# Paseo Del Norte Boulevard NE

## DRAINAGE MANAGEMENT PLAN

Sheet Title:  
GRADING AND  
DRAINAGE  
MANAGEMENT PLAN

C1.1

C1.1

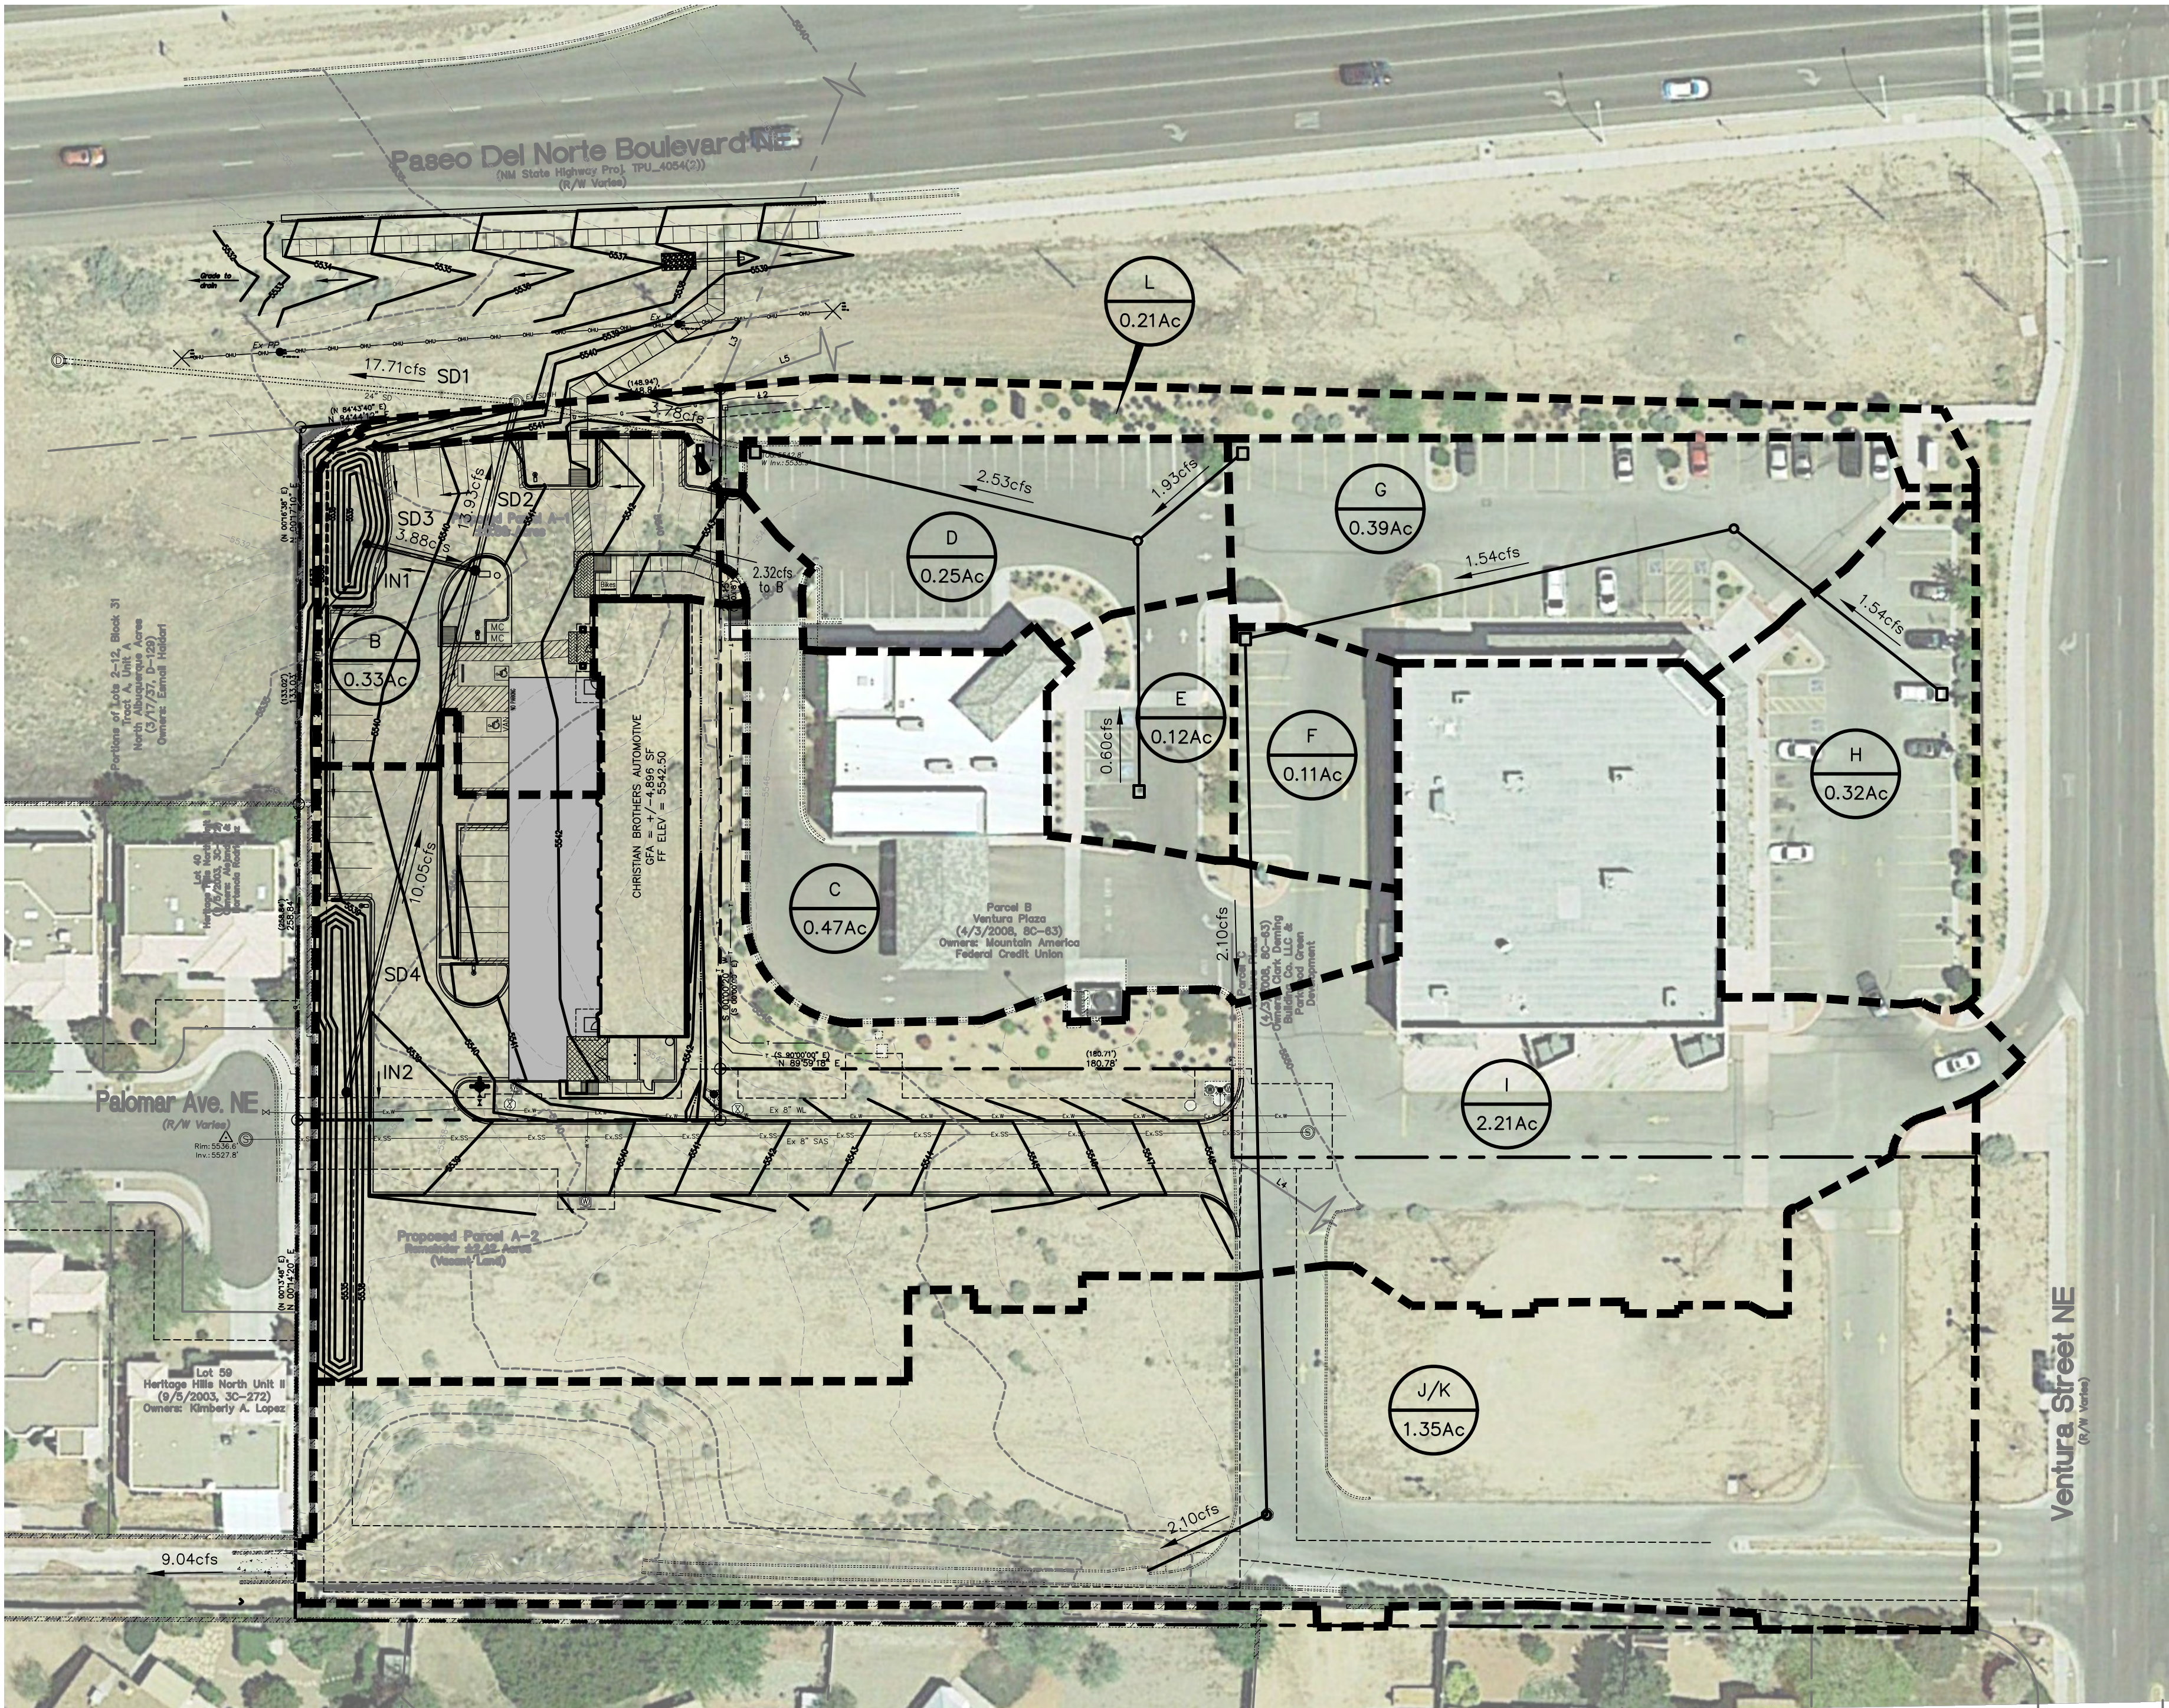
ADD SWALE DETAIL.  
100YR. 6hr CALCULATIONS.  
SHOW FIRST FLOOD CALCULATIONS.  
SHOW CURB CUT WEIR CALC.  
SHOW PRIOR TO CONNECTING INTO EXIST. M.H.; NM DOT PERMIT IS NEEDED.  
NEED TO SHOW STORM SEW PIPE CAPACITY WITH HGL.  
NEED TO SHOW EXISTING STORM SEW CAPACITY CAUS W/ HGL + PROPOSED DEVELOPMENT CAPACITY & HGL.

CALL OUT STORM SEWER PIPE SIZE, TYPE, SLOPE, & LENGTH.

NEED SUB-  
DRAINAGE  
MAP.
